CITY OF ALBUQUERQUE

October 20, 2014

RE: Lot 6, Lowe's Subdivision
Conceptual Grading and Drainage Plan
Engineer's Stamp Date 10-2-2014 (B14D016)

**SOUTHWEST VETERINARY MEDICAL CENTER
LOT 6, LOWES SUBD., ALBUQUERQUE, NEW MEXICO
GRADING AND DRAINAGE PLAN**

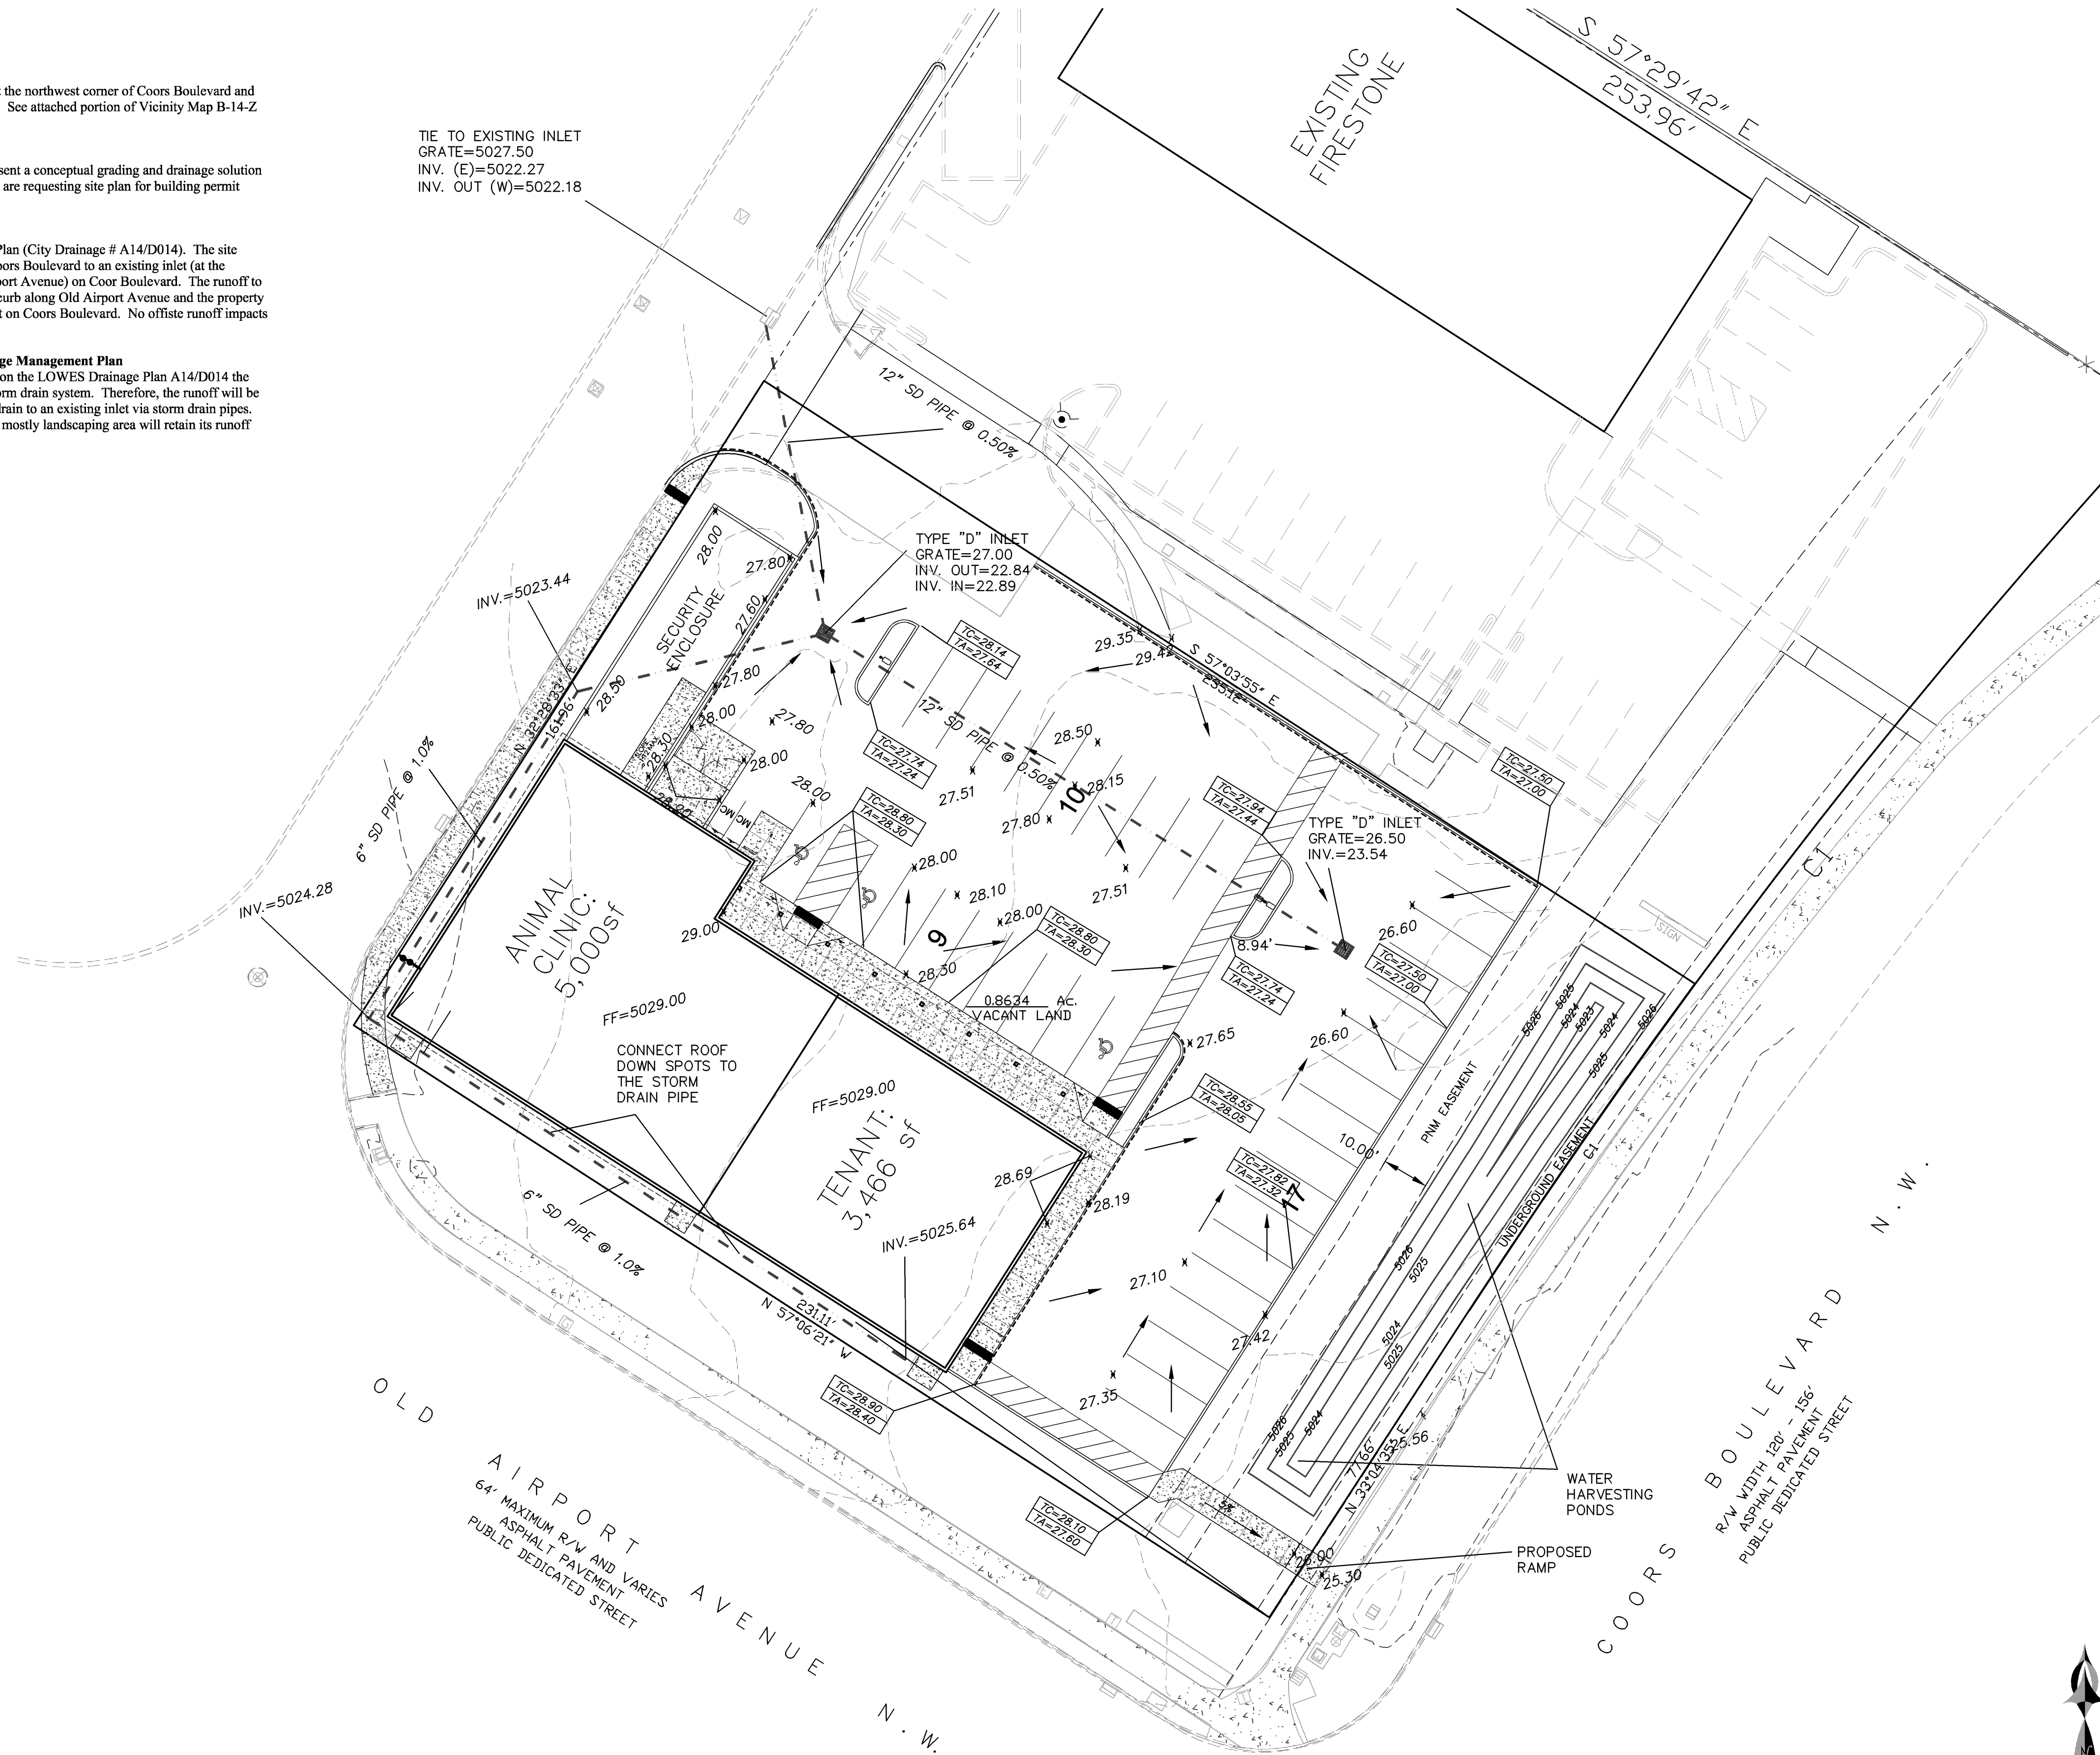
1. Show on plan and state in the narrative how the first flush is to be managed. It seems that water should be directed to water harvesting pond before being captured by inlet.
2. Maintain the 2.94 cfs allowed by the Lowe's Drainage Master Plan when determining how to manage the first flush.
3. Water harvesting pond appears to be in a PNM easement. Indicate the easement boundaries on the plan.
4. Show land treatment areas/percentages in the calculations.
